Subject: Lot 4 Patterson – Halifax II plan by Haynes Home Plans, Inc

At your request, I reviewed the Halifax II plan being constructed at Lot 4 Patterson. Specifically, I reviewed the point loads from the truss girder bearing on the monolithic slab footing.

**MONOLITHIC SLAB PLAN**  
**The Halifax II**

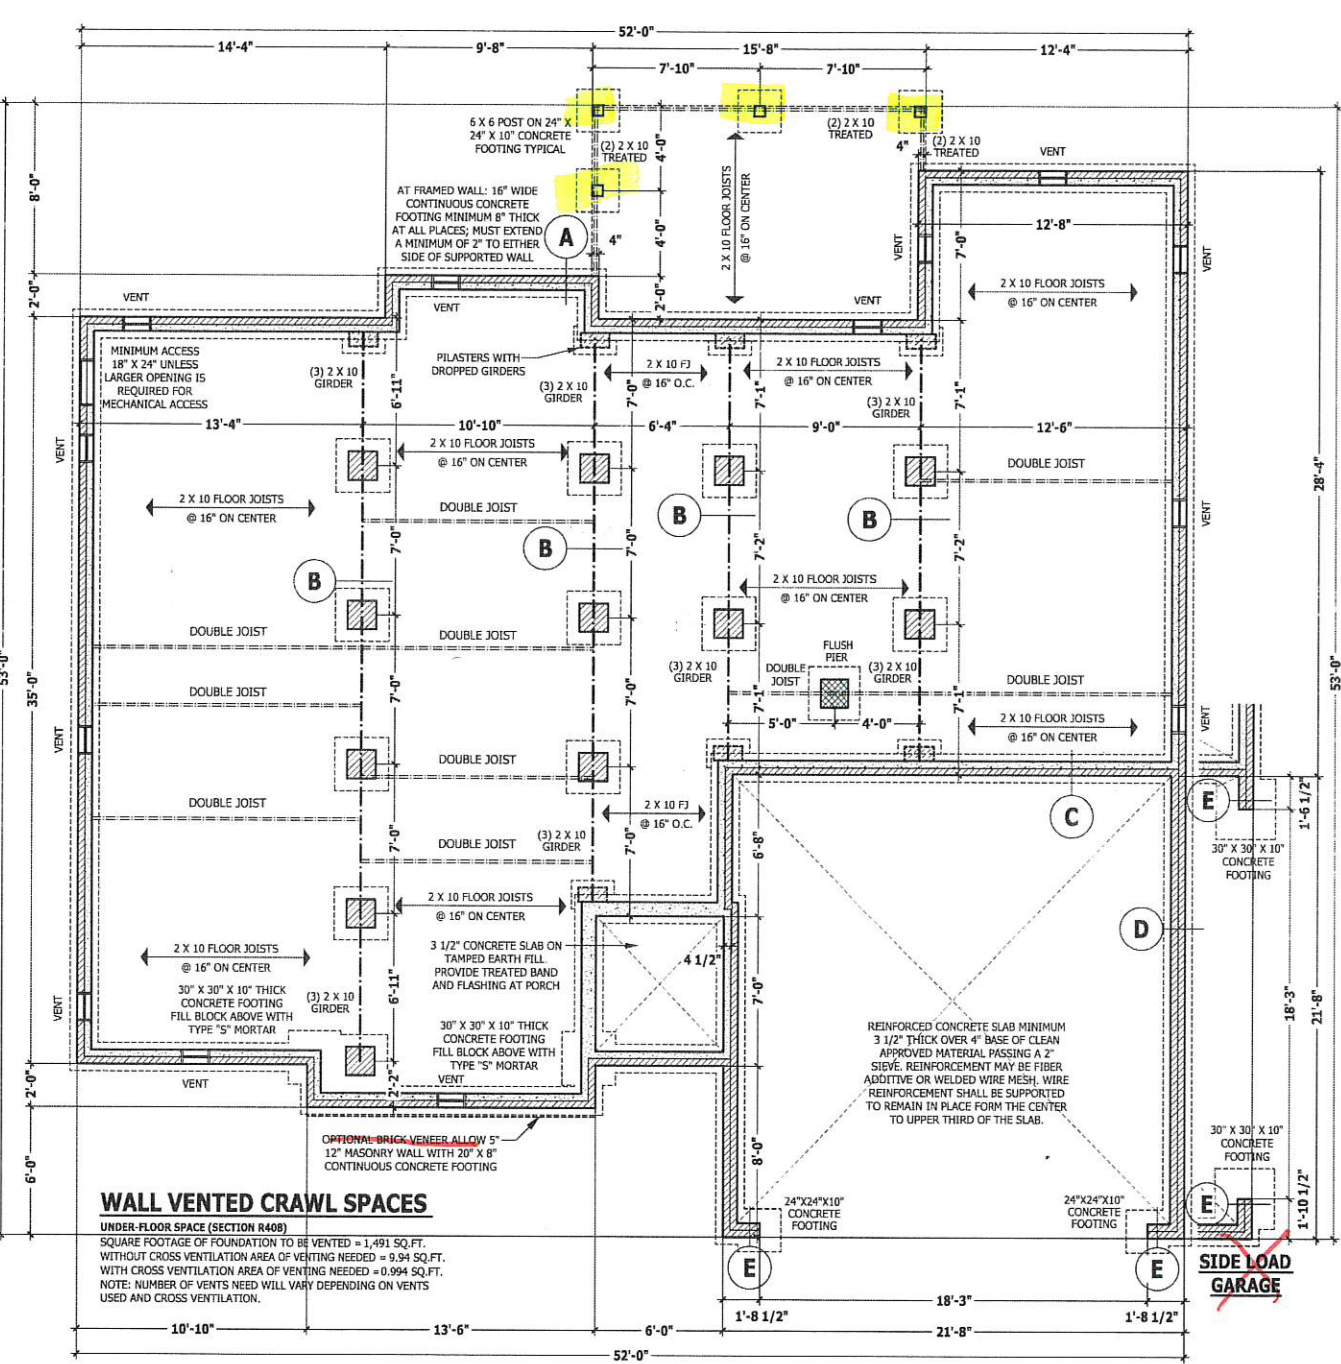
Based on by review and analysis, the point load created by the truss girder exceeds the allowable load for a point load on the outer footing on the left side of the home. In lieu of directly bearing the truss girder on a stud column in this location, install a 3' long (2)1.75"x9.25" LVL "header", directly under the truss girder, such that the truss girder is centered over the header. The header should be supported on each end by a minimum of (3) studs. Studs may be placed within the 3' opening created by the header but should be single studs. The header will distribute the point load to a wider area, thus distributing the load to allowable forces. The opposite end of the truss girder bears on a corner of the slab footing (adjacent to the entryway). Based on the distribution of loads in multiple directions due to the corner loading, it is adequately sized to support the load on that end.
